**Application Reference: 3/2026/0214 - Full Planning Application: Erection of 26 no. Affordable Dwellings with Associated Access, Gardens, Parking and Landscaping.
Land at Albany Drive, Copster Green, Ribble Valley**

- 1.1 Further to correspondence dated the 4th June 2026, outlining the Council's reluctance to support Planning Application 3/2026/0214 at Land off Albany Drive, Copster Green, please accept this supplementary letter as a response to the issues and objections raised. This letter has been produced on behalf of Pringle Homes ('Pringle' or the 'applicant') by Maybern Planning and Development Limited ('Maybern').

Drawing Title:
SITE SECTIONS

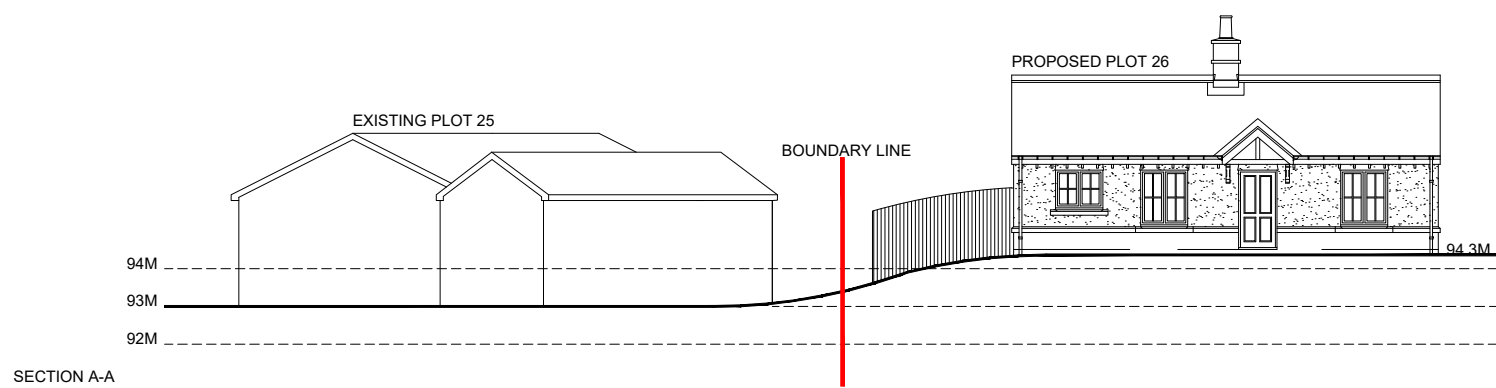
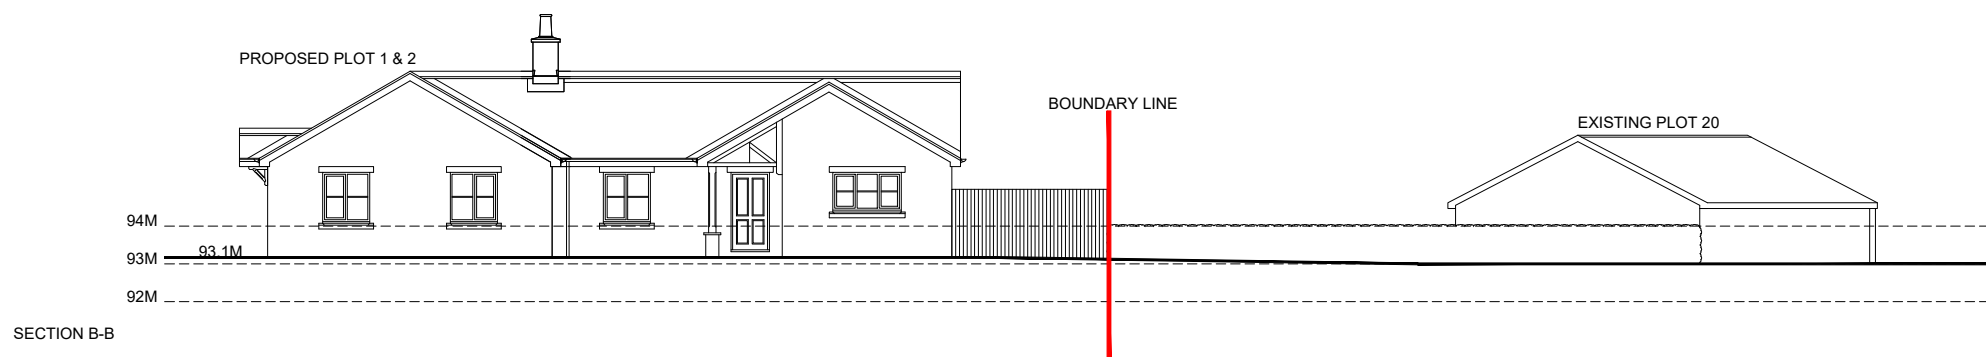
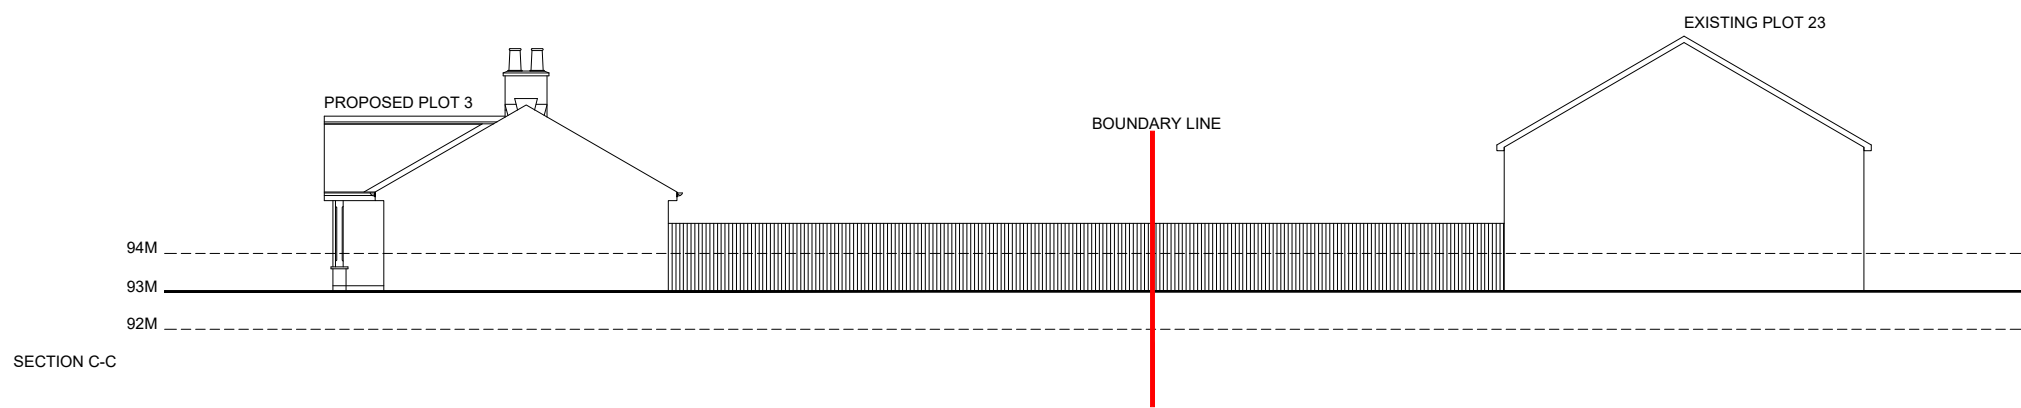
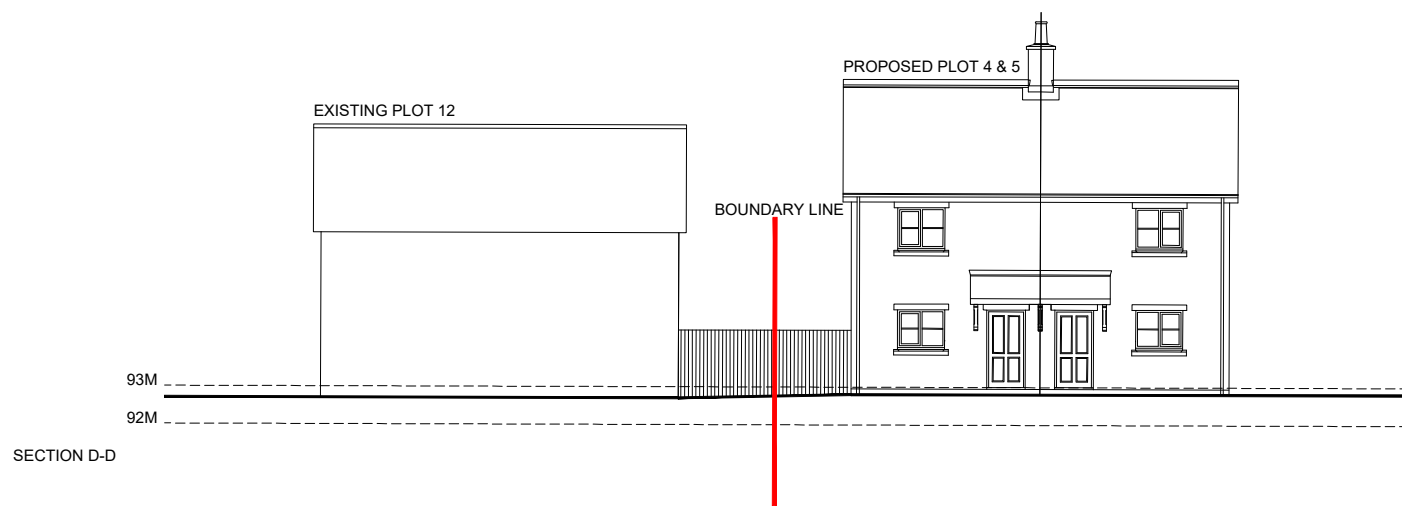
- 1.31 A Section and finished floor levels are provided for the site; both are provided through the provision of Site Section 24-133 SX01 Rev A.
- 1.32 With regard to the Lighting Assessment request; while the applicant is willing to have an assessment prepared, it has not been possible to instruct any such exercise. The Council has not provided formal comments from the EHO such that it could be scoped and the applicant's position on the matter is that the proposed scheme is of a very similar character to existing residential development that surrounds the site. It remains unclear as to the basis for these concerns and it is requested that the officer consider imposing a condition requiring a lighting scheme prior to the commencement of development.
